Suffolk County Council (20050784)

Final Position Statement

North Falls (EN010119)

23 July 2025

# **Onshore Substation Zone of Theoretical Visibility and Viewpoint Locations with Dedham Vale National Landscape**

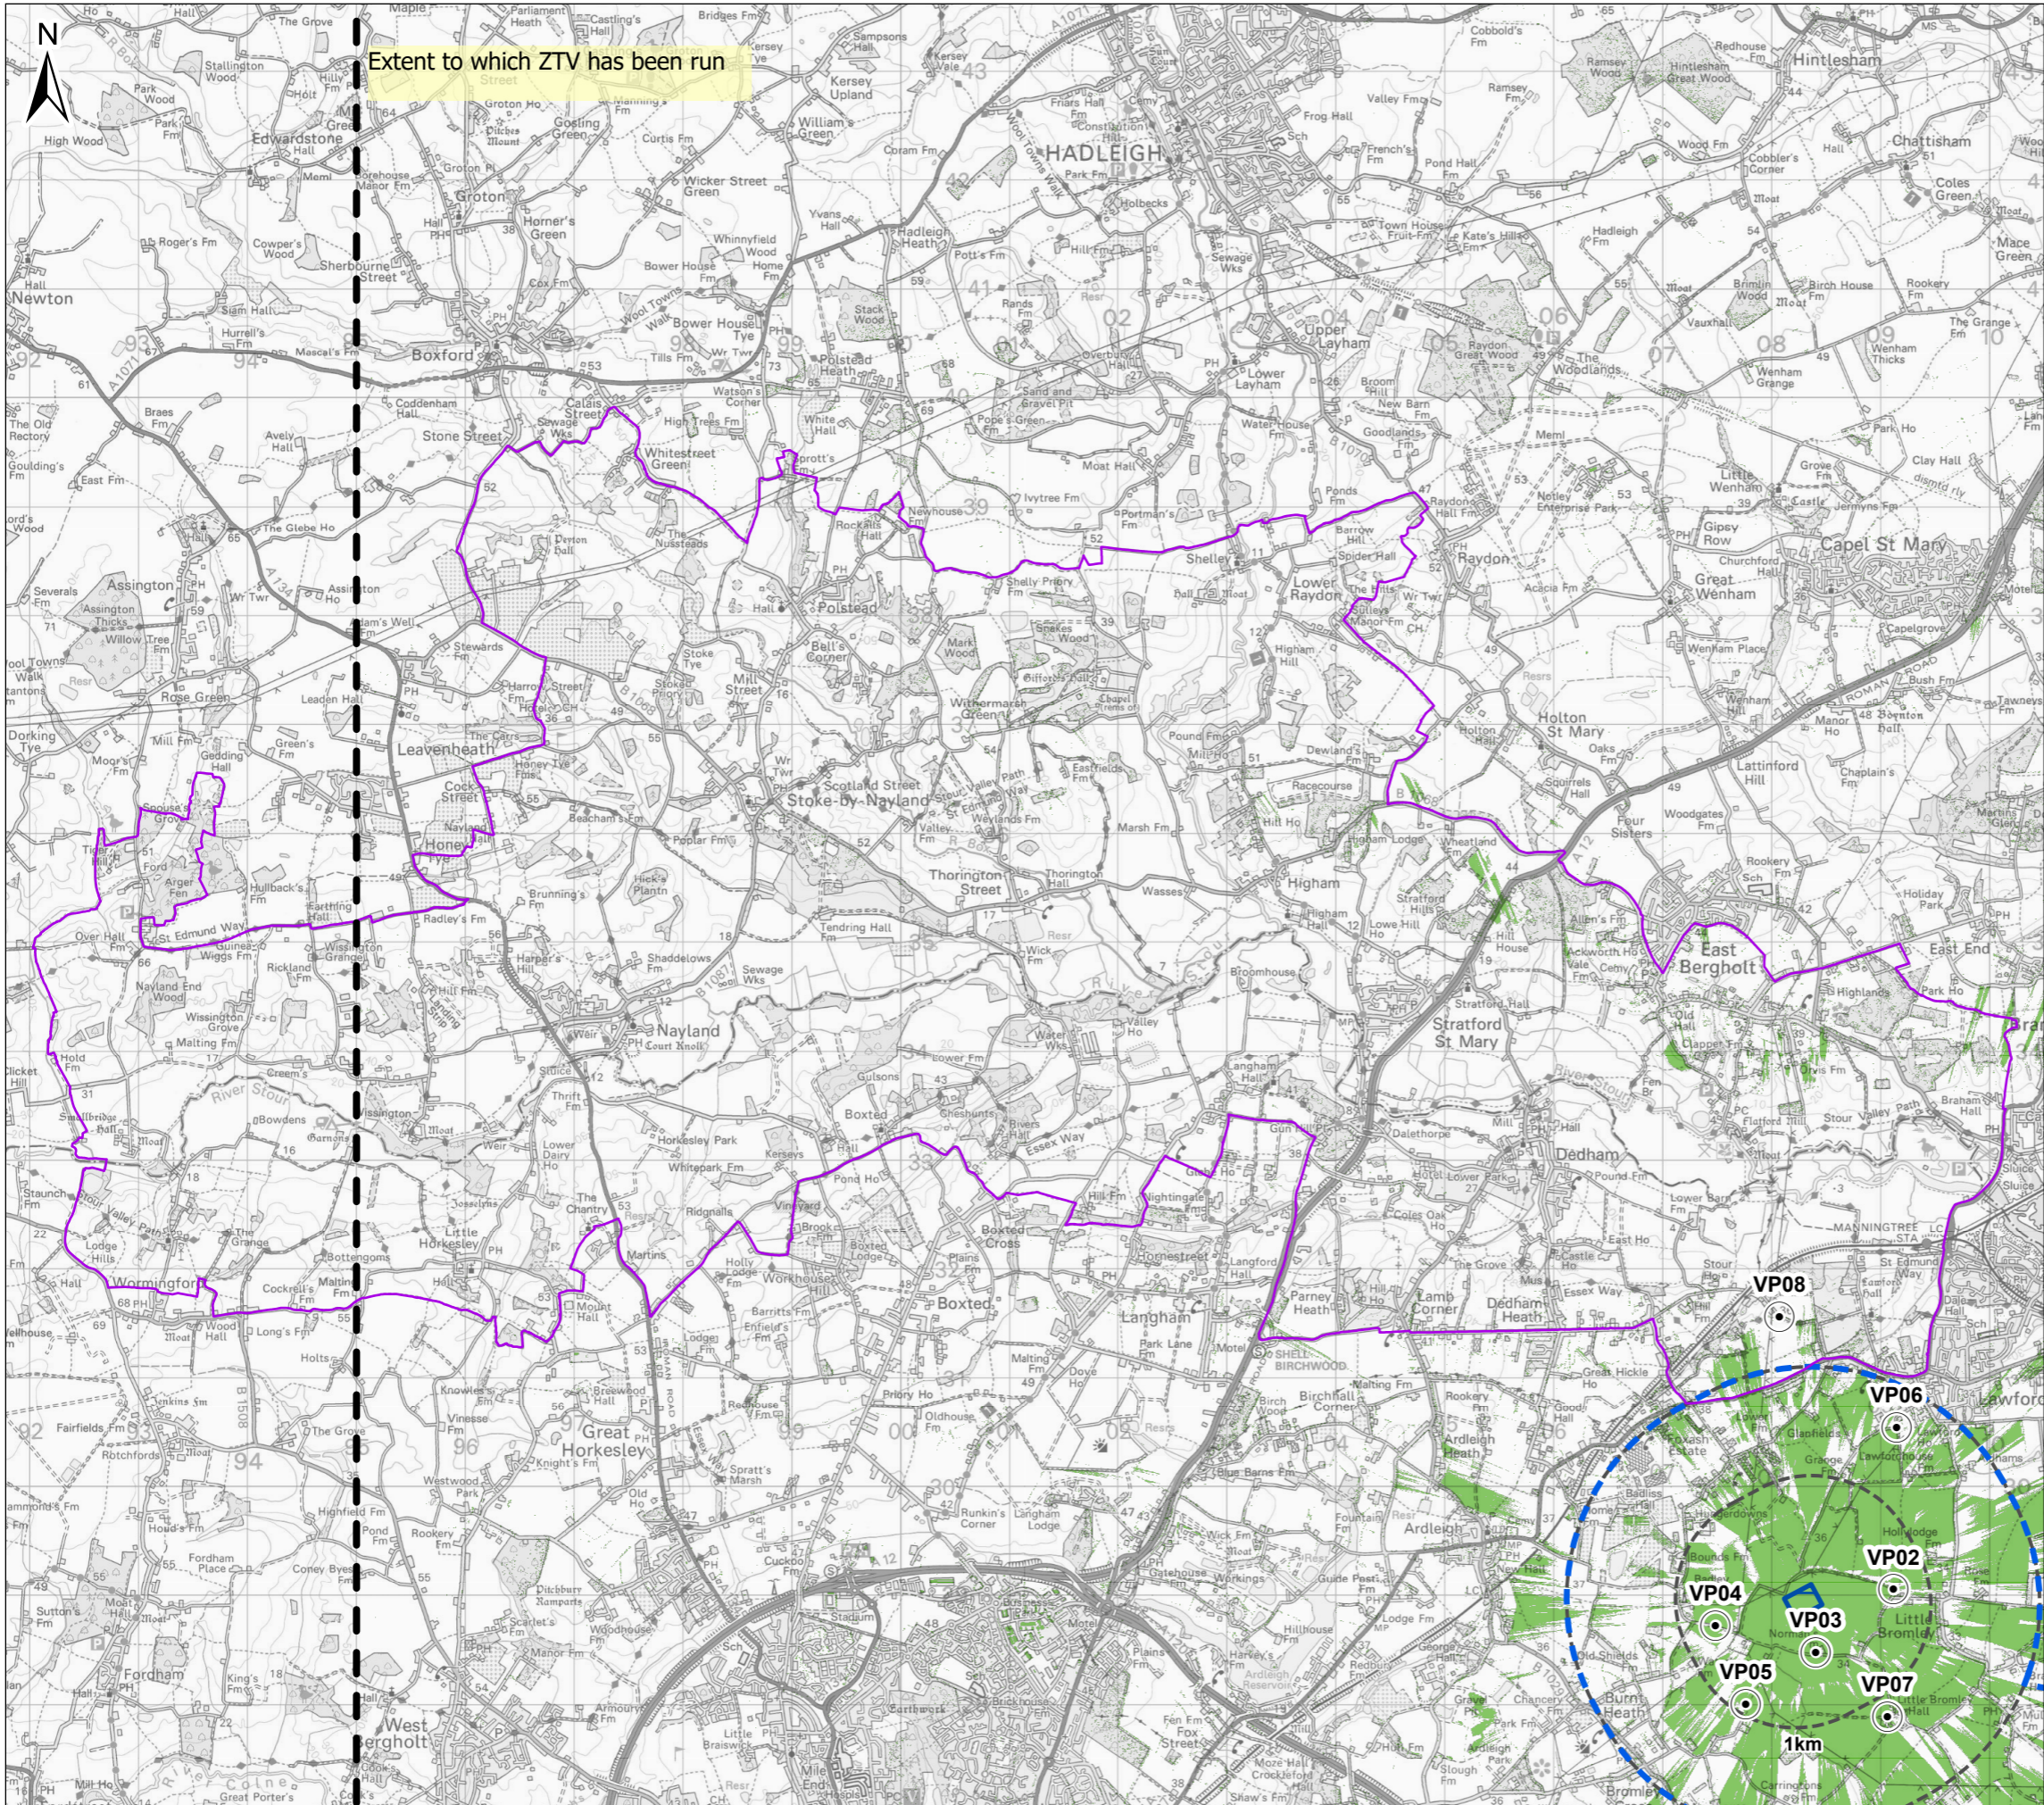
- 5.3 Paragraph 7.26 details SCC’s concerns surrounding the unassessed zones of theoretical visibility with the DVNL as indicated by figure 30.2.8 [APP-088]. SCC considers it necessary to fully assess the impacts of the proposed development on the DVNL to ascertain whether the proposed development affects the DVNL in the context of the s.85(A1) CROWA 2000 duty. SCC reiterated this point during ISH 1 and SCC’s corresponding written summary [REP4-094] and in its comments on deadline 4 submissions [REP5-116], where SCC also suggested the inclusion of an additional viewpoint along the Essex Way south-west of viewpoint 8 to ensure that the impacts on the DVNL are fully assessed. In response to deadline 5 submissions [REP6-092], SCC clarified that it does not equate visibility with adverse effects. SCC recognises that it is the extent and nature of visual impacts which can lead to conclusions on adverse effects, and this is a matter for professional judgement and assessment. SCC understands that the duty would be engaged were the visual effects of the proposed development found to have a detrimental effect on the special qualities or natural beauty indicators of the DVNL. SCC’s concern is that the information thus far provided

by the Applicant provides an insufficient assessment of the visual impacts of the substation proposal on the DVNL.
